File: SF19/115899
Job ID No: DOC19/974981
Your Ref: SSD 9794

Mr Karl Fetterplace
Senior Planning Officer
Key Sites Assessments
Department of Planning & Environment
Level 29, 320 Pitt Street
SYDNEY NSW 2000

RE: Response to Exhibition of Sydney Opera House (SOH) Lower Concourse Minor Works and Uses (SSD 9794)

Location
Lower Concourse, Sydney Opera House, Bennelong Point, Sydney
Drawing
Detail Plan - Shade Structure

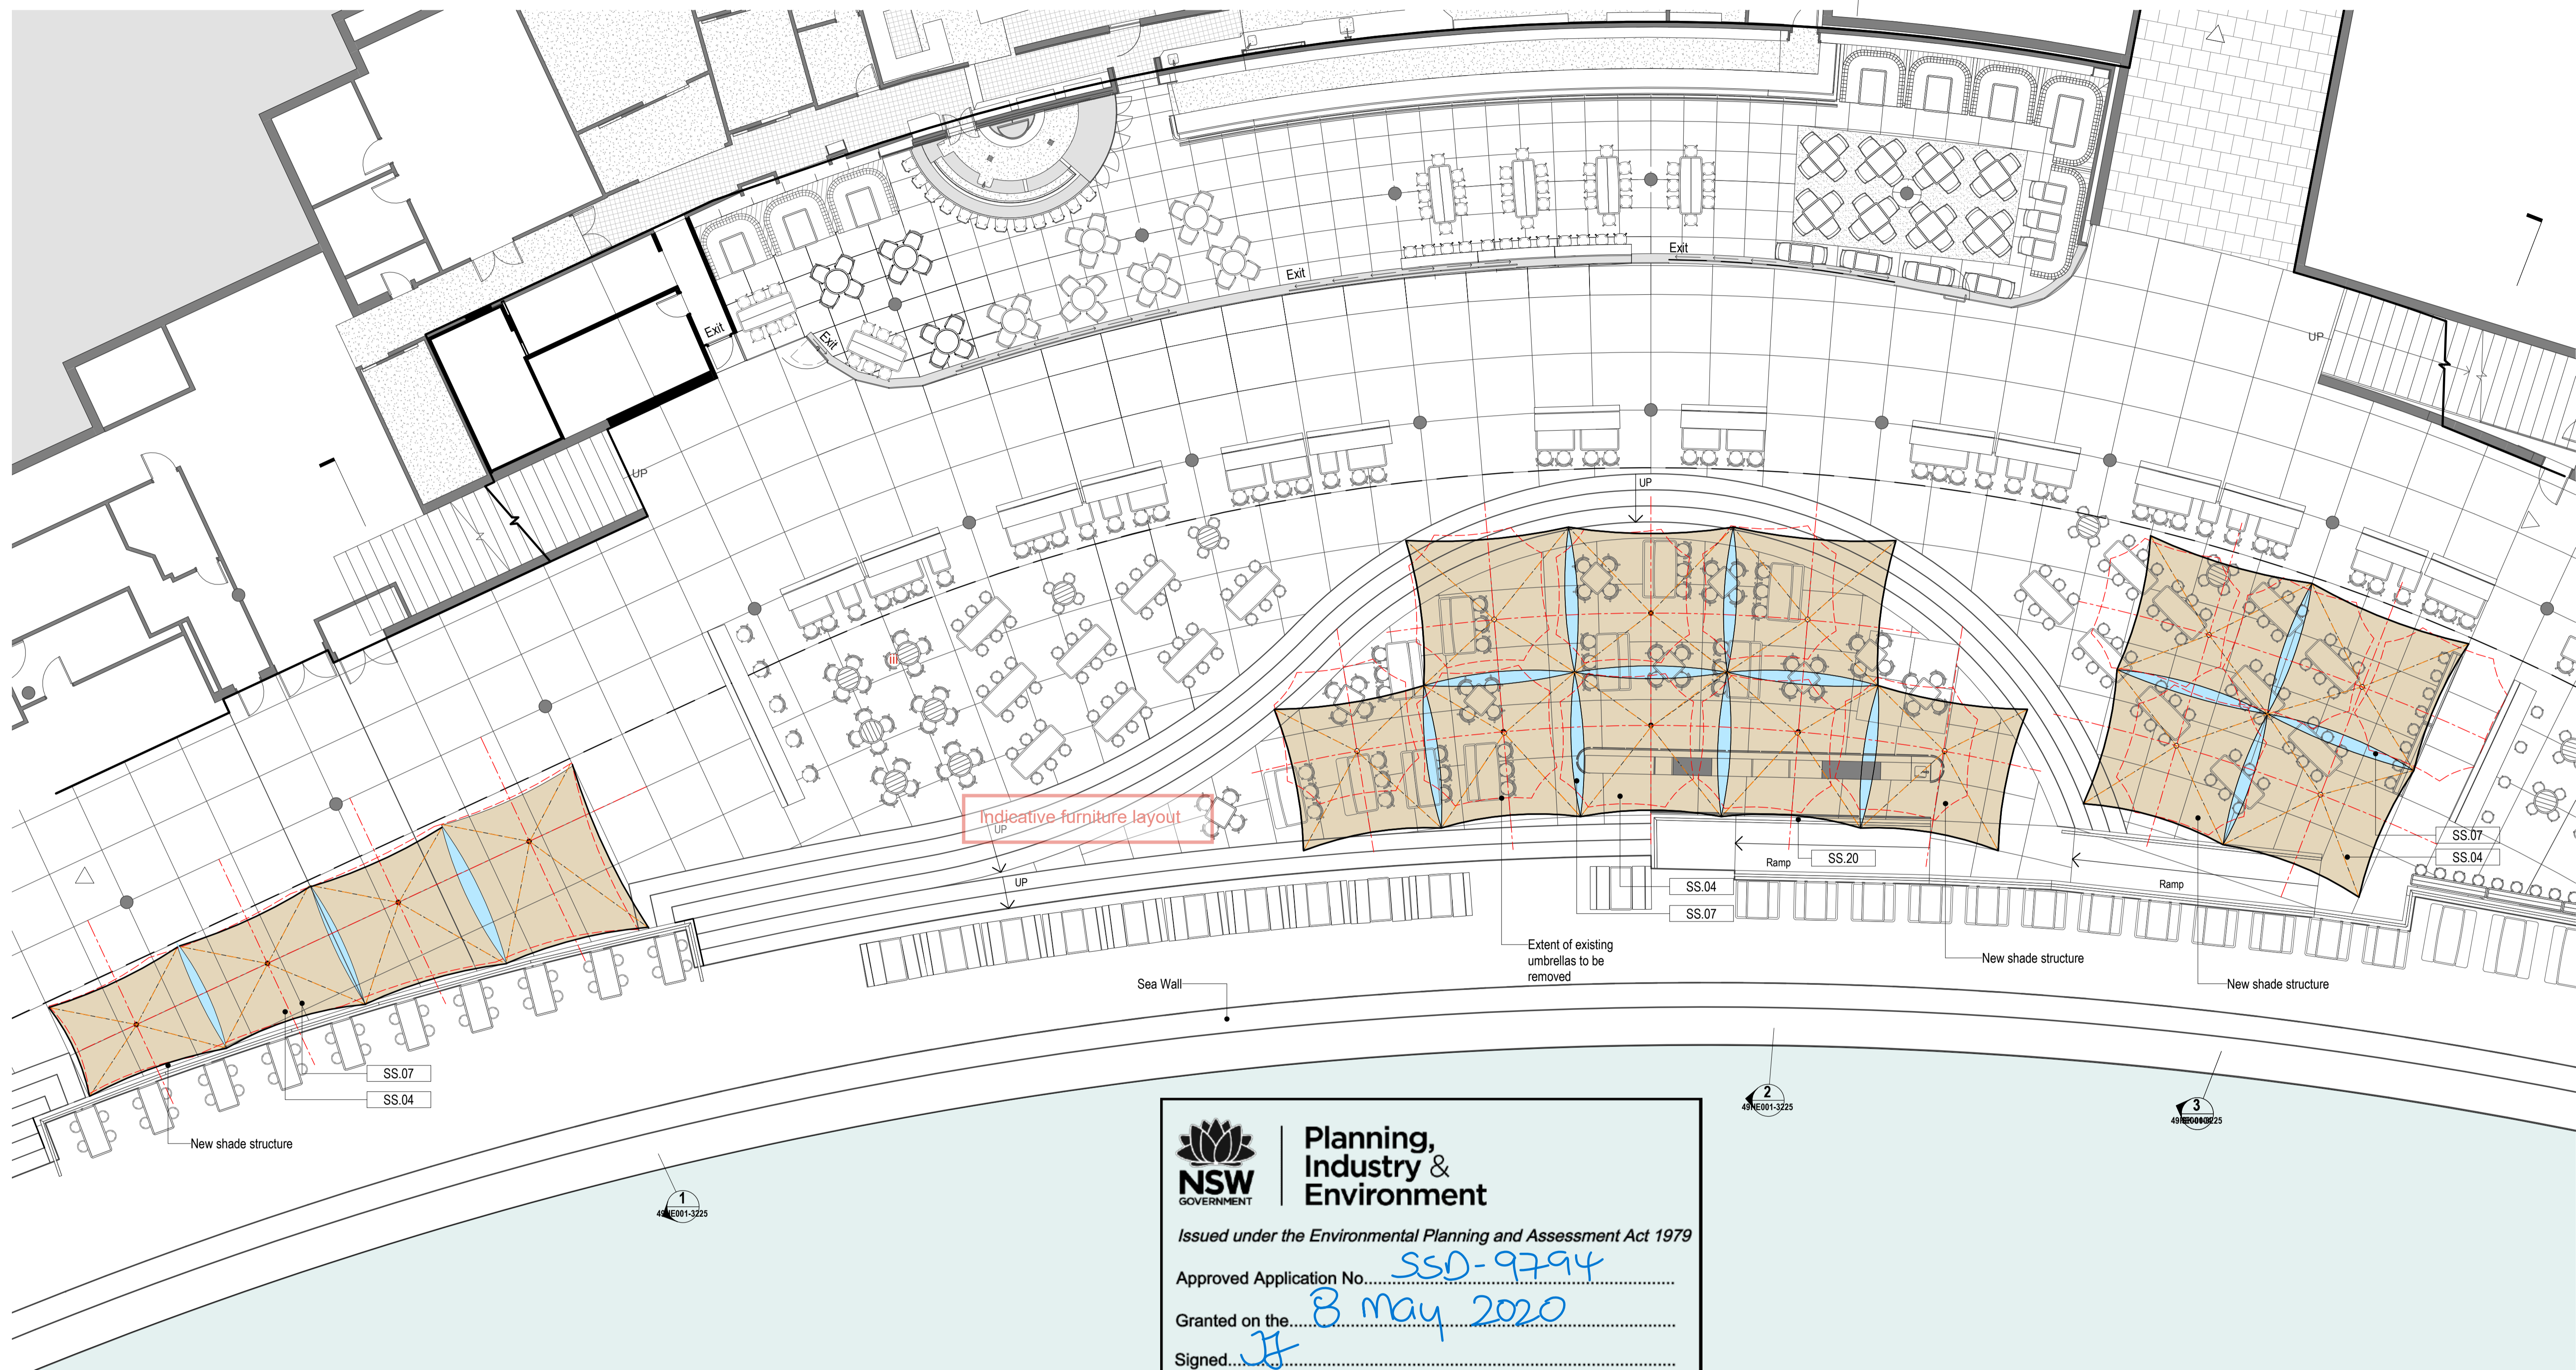
- Further details of the proposed free-standing pull-up shade screens should be provided to assist in assessing impacts of these elements.
- The opacity of the translucent infill sections of the shade structures should be tested to ensure the infill panels allow adequate light and vision through to minimise the appearance of a large continuous roof within this outdoor space.

Location
Lower Concourse, Sydney Opera House, Bennelong Point, Sydney
Drawing
Detail Elevation - Shade Structure

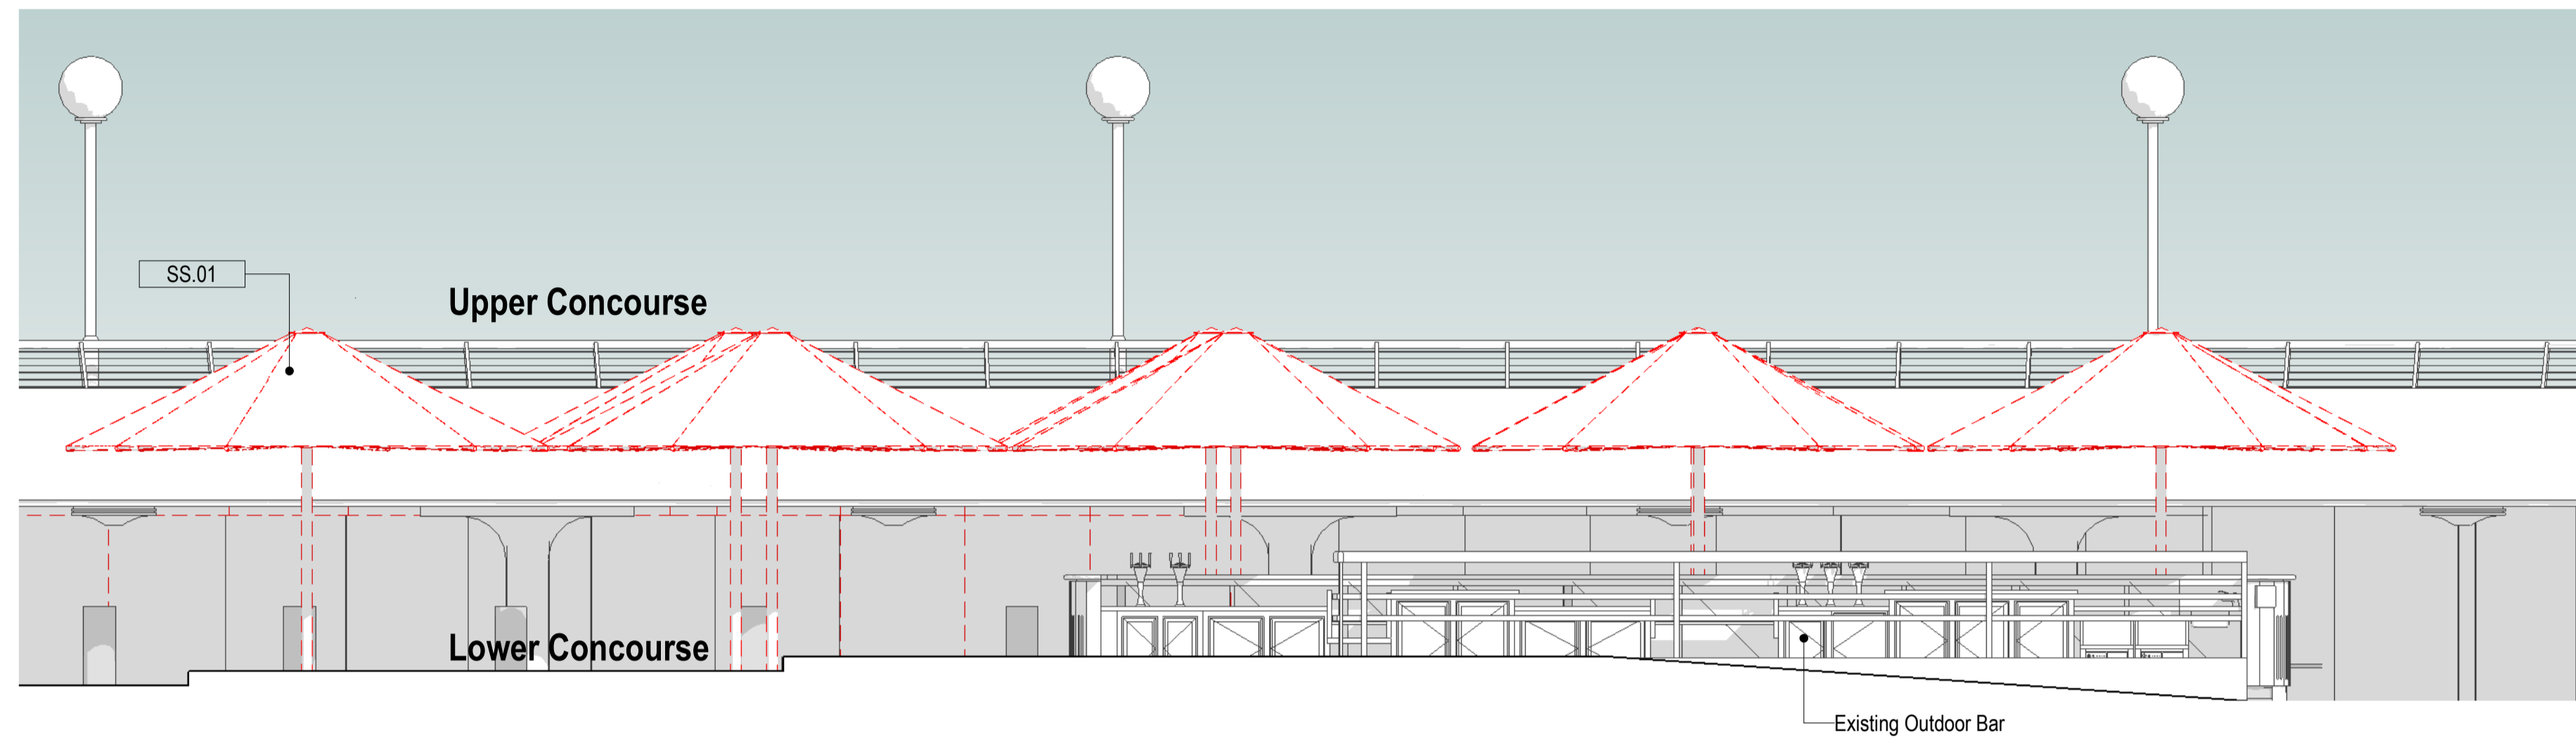
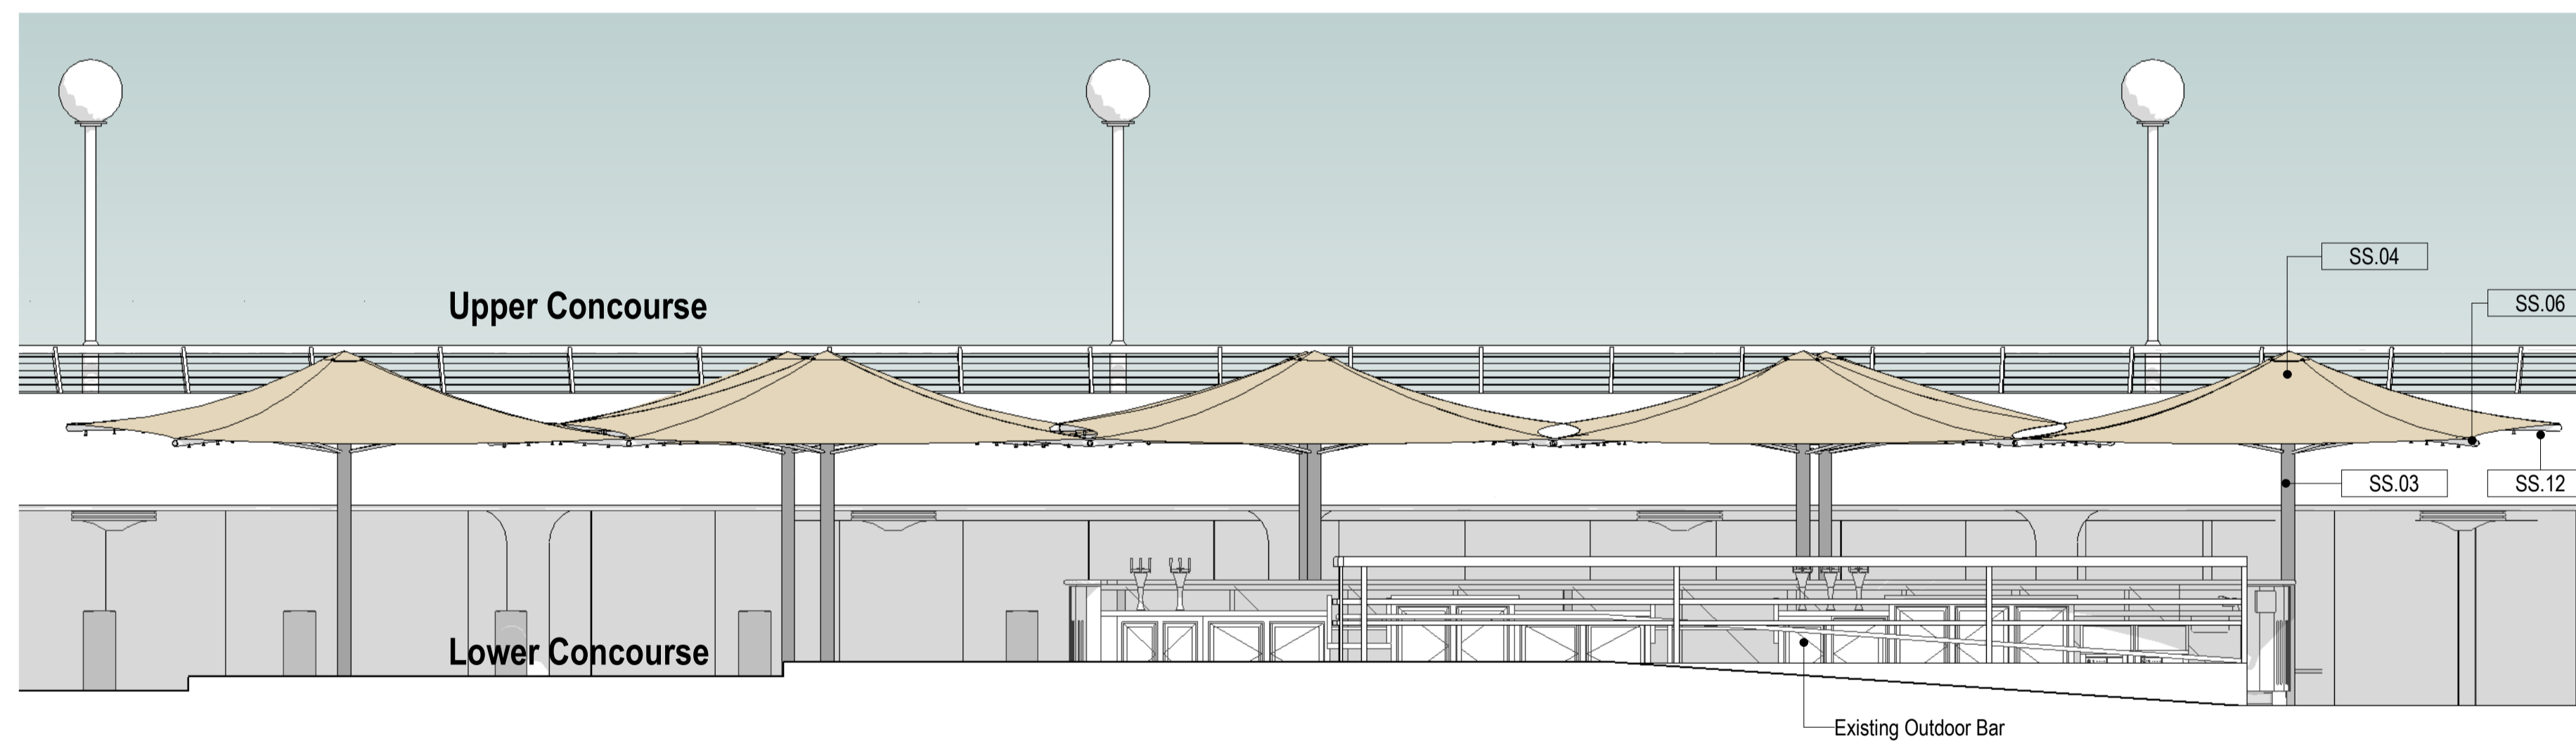
- It is noted that the new shade structures will replace existing umbrellas in similar configuration and location.

- The shade structures are an improvement on the existing design, as they are simpler in form with a shallower profile than the existing, propose a colour which does not contrast with the natural materials used in public spaces, and incorporate services within the shade structure which will minimise visual clutter.
- It is noted that the shade structures will be grouped together with translucent infill sections connecting each shade structure to maximise weather protection. The translucent infill will assist in minimising the appearance of a continuous roof structure provided they allow enough light and vision through the infill material.
- The documentation notes free standing pull-up shade screens are proposed behind the Outdoor Bar and that these elements will be subject to future detail design development with the DAP.
